Application by One Earth Solar Farm Limited for One Earth Solar Farm The Examining Authority's written questions and requests for information (ExQ2)

Issued on 30 September 2025

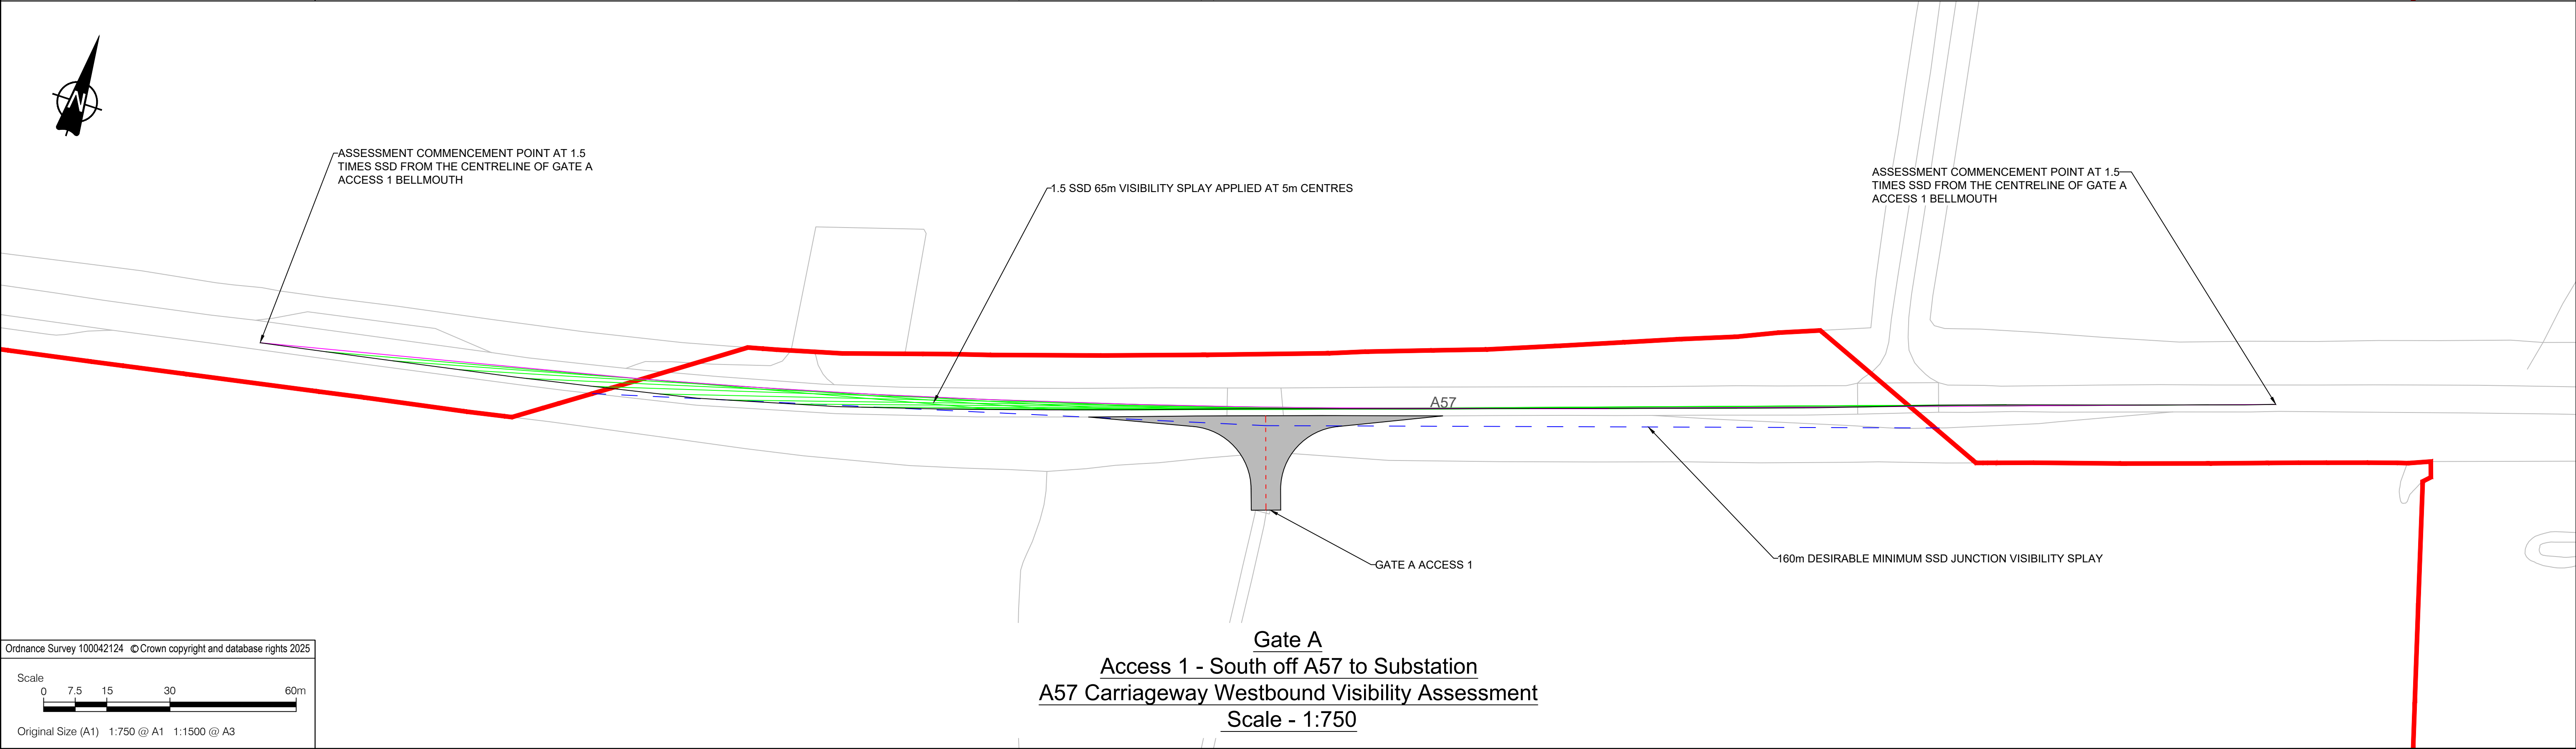
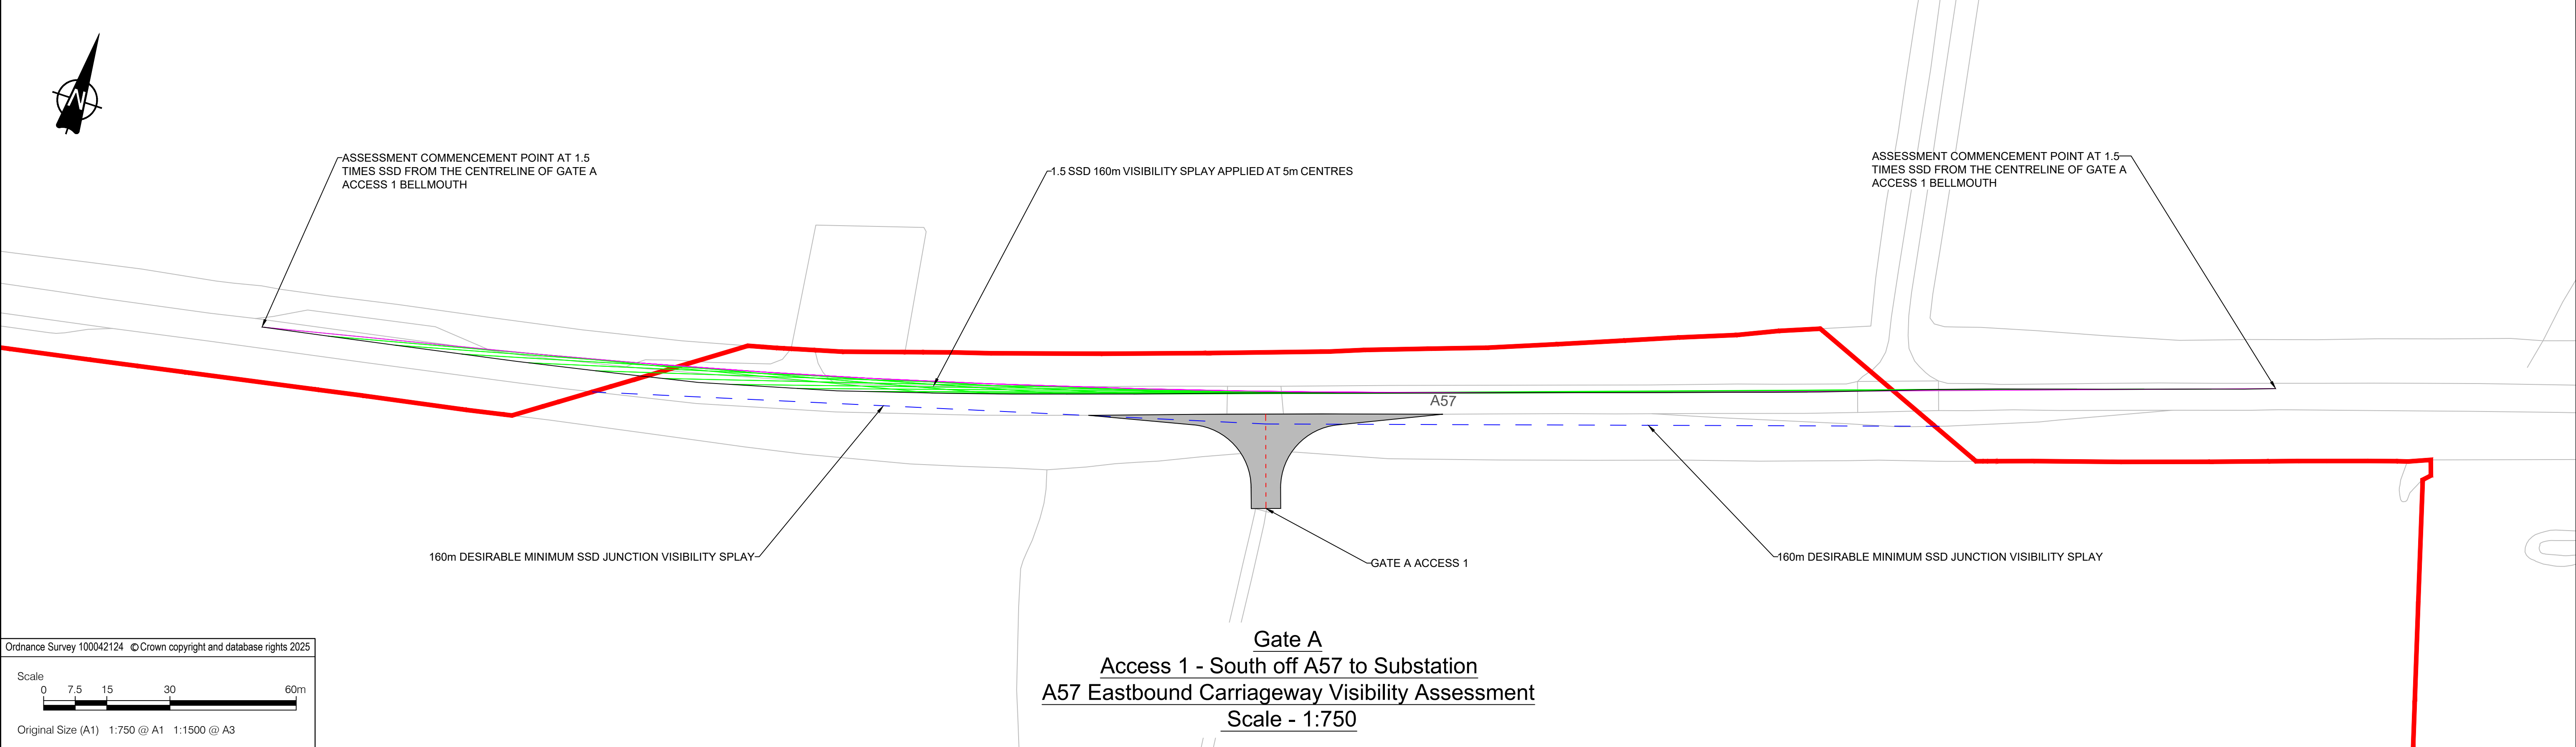
ExQ2	Question to:	Question:
	The applicant	<p>The submission at Deadline 3 from NCC [REP3-085] includes comments on the applicant's previous response to the LIR. These comments include the following:</p> <p><i>"Access 1 (Gate A) – The need for a ghost island in accordance with DMRB is queried as the construction peak period daily traffic flow shown in Table 4 of the TA exceeds that indicated as acceptable for a simple priority junction in Figure 2.3.1 of DMRB CD123. The swept paths should identify corresponding opposing movements on the same viewport. There appear to be conflicts between opposing movements."</i></p> <p>(1) Is a ghost island an appropriate junction type for the operational and decommissioning phases of the proposed development?</p> <p>(2) Are there any potential risks to road safety of a ghost island junction with the likely number of vehicle movements that will occur during the operational and decommissioning phases of the proposed development?</p> <p>(3) If the applicant does not provide a ghost island, would NCC consider the access point to be safe?</p> <p>(4) Can the applicant confirm the duration that vehicle movements at this access point would be above the threshold for a simple priority junction? Alternatively provide evidence why the threshold would not be met</p> <p>(5) Would the provision of a ghost island in this location lead to any additional land take, over and above what is currently proposed in the dDCO?</p> <p>(6) What other issues, aside from highways-related issues, would be caused by the use of a ghost island? For example, would there be landscape or visual impacts that need to be assessed?</p>
